Ribble Valley Borough Council
Housing & Development Control

Application no: **3/2023/0586**

Address: **Root Farm Dunsop Bridge Clitheroe BB7 3BB**

Proposal: **Approval of details reserved by conditions 4 (solar panels), 6 (landscaping), 8 (construction management plan/method statement), 11 (highway works) and 16 (service management plan) of planning permission 3/2021/0952.**

6.07 SITE TRAFFIC MANAGEMENT PLAN

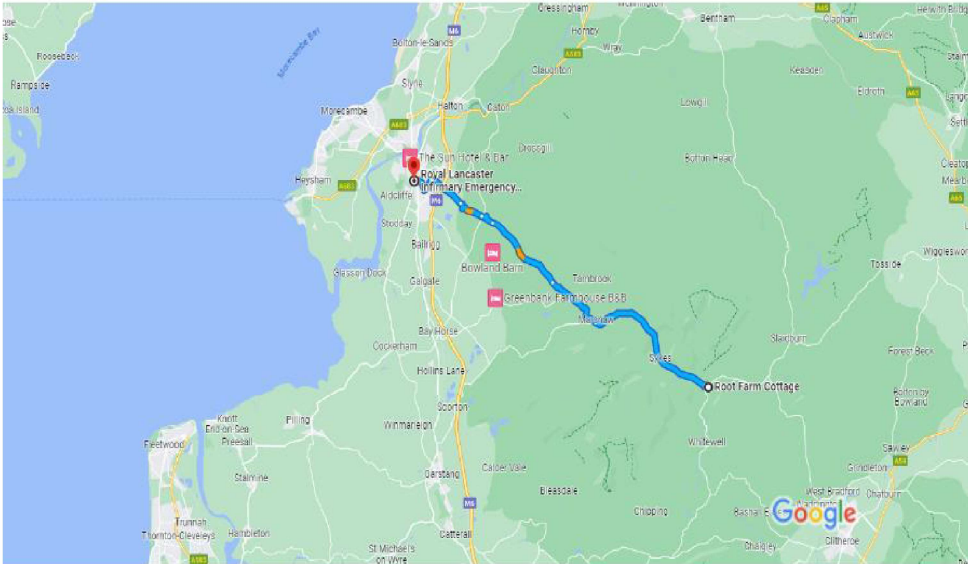
The LHA have reviewed the Construction Management Plan and the Traffic Management Plan and have no objection to the condition, granted that the traffic signs will not be implemented within the carriageway of the adopted highway.
